UPDATE OF LIST OF PLANNING APPLICATIONS TO BE DECIDED BY

Planning Application 2026/90484

Change of use from dwelling to C2 for 4 children, erection of first floor extension and front porch, internal and external alterations

143, Church Lane, Gomersal, Cleckheaton, BD19 4QN

Proposed First Floor General Arrangement Plan 1:50

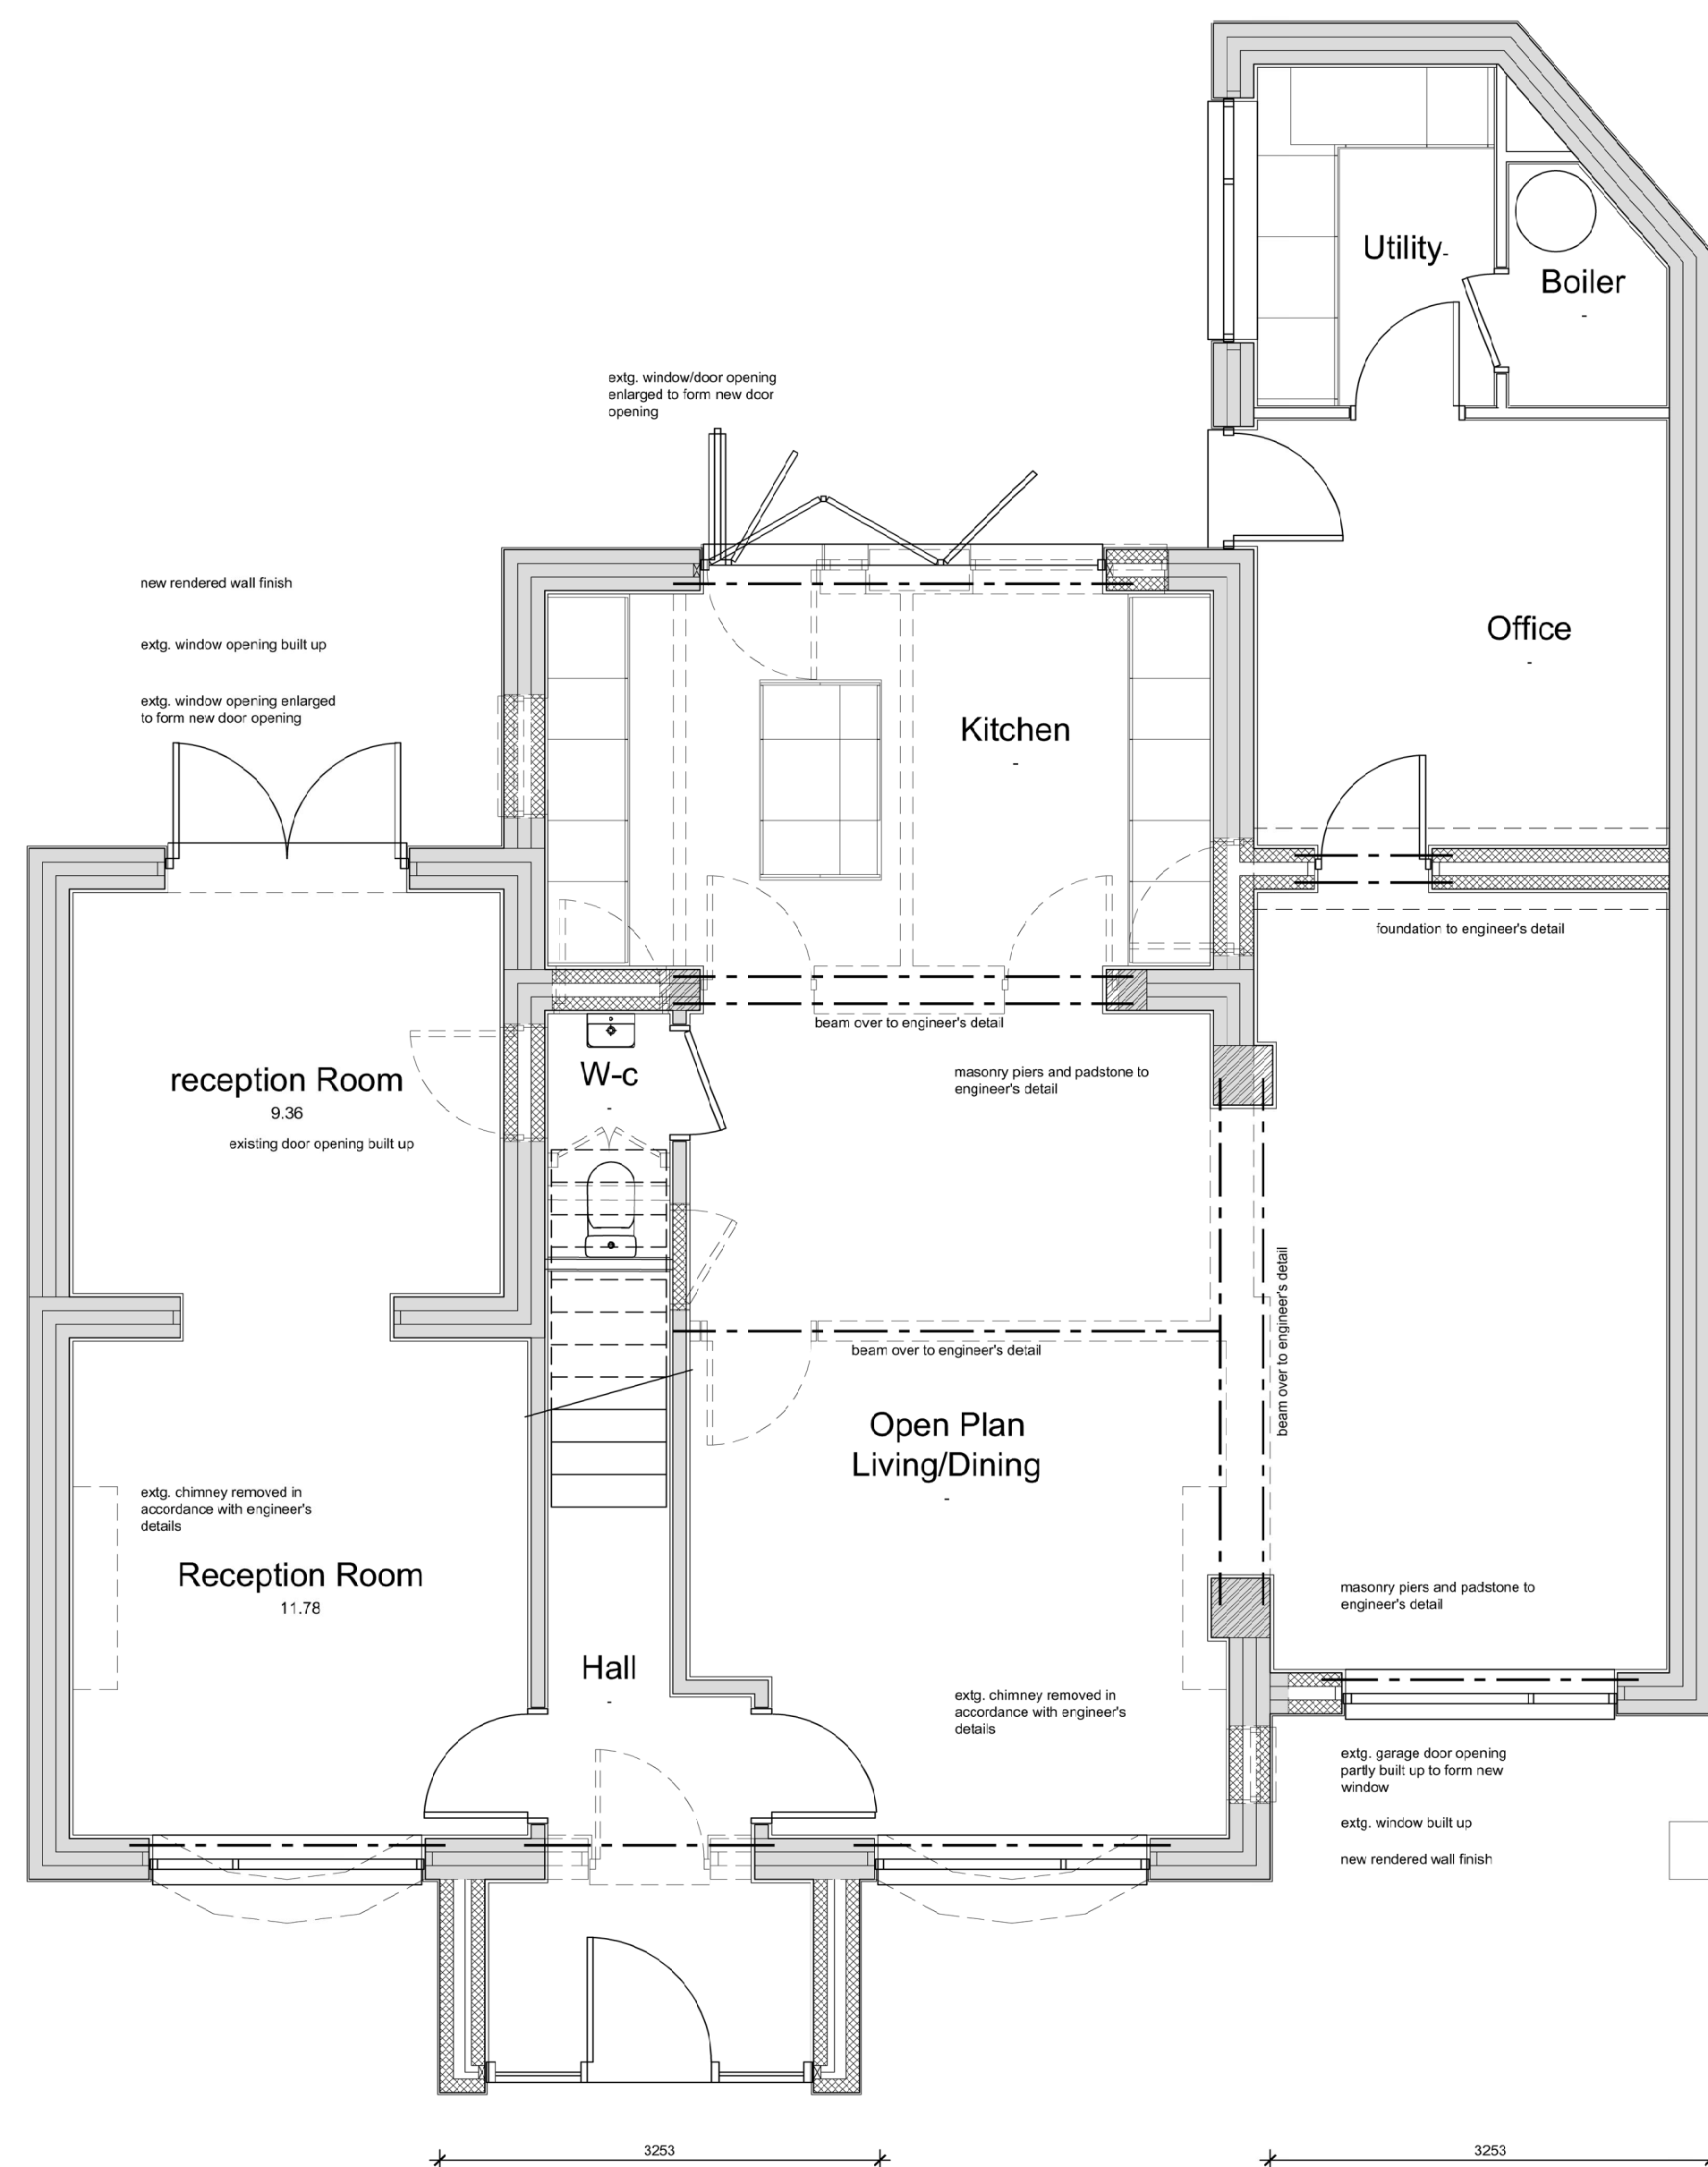
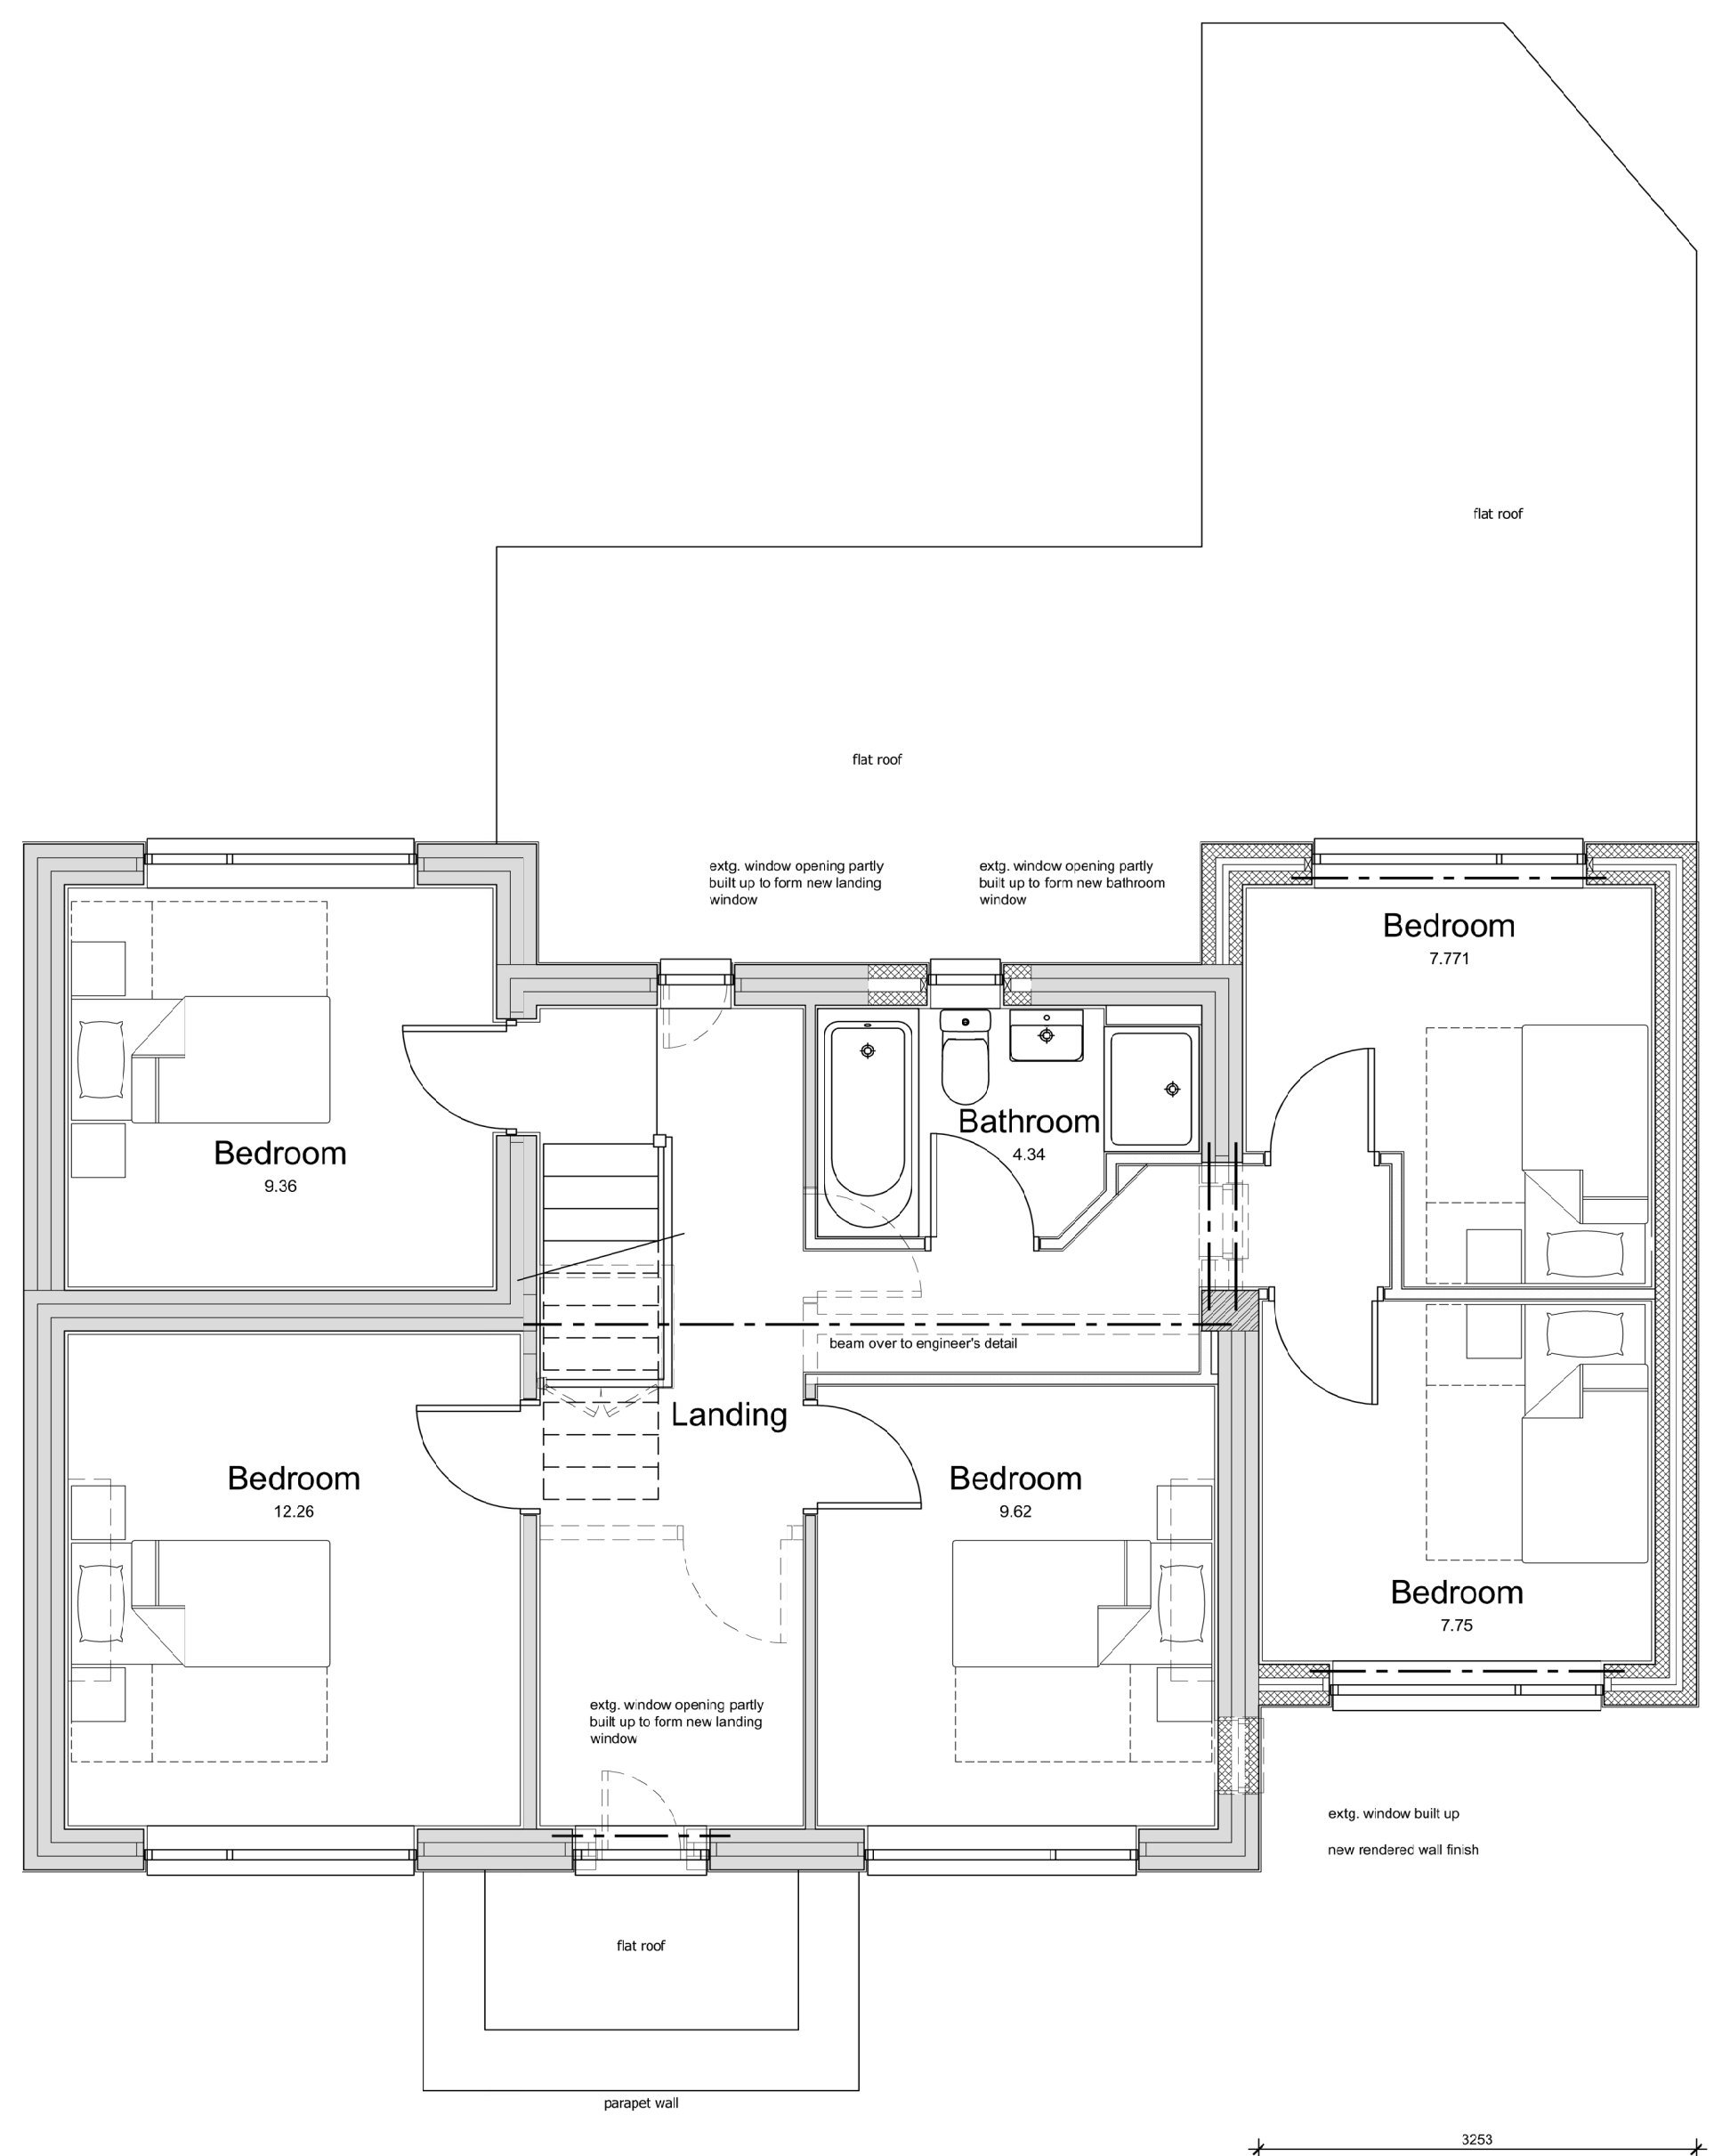
The proposed 1st floor extension will have a more significant impact on No1 Coppice due to its elevated position and the complete lack of any openings.

The proposed bedroom window will overlook the decked area and proportion of the garden, being only 0.8m away from the boundary wall, removing the right to privacy.

Should the first-floor extension be granted there would be direct access to the flat roof of the former garage via fire escape windows. This would give escape routes for absconding via No 1, 3 The Coppice using the garage roof of No1, also into the field adjoining the back yard of 143.

The concerns regarding overshadowing, overbearing impact and overlooking have been carefully considered. Having regard to the orientation of the site, the relationship with neighbouring properties and the separation distances involved, it is not considered that the proposal would result in a level of overshadowing, loss of light, overbearing impact or overlooking sufficient to warrant refusal. The proposal is therefore considered acceptable in residential amenity terms.
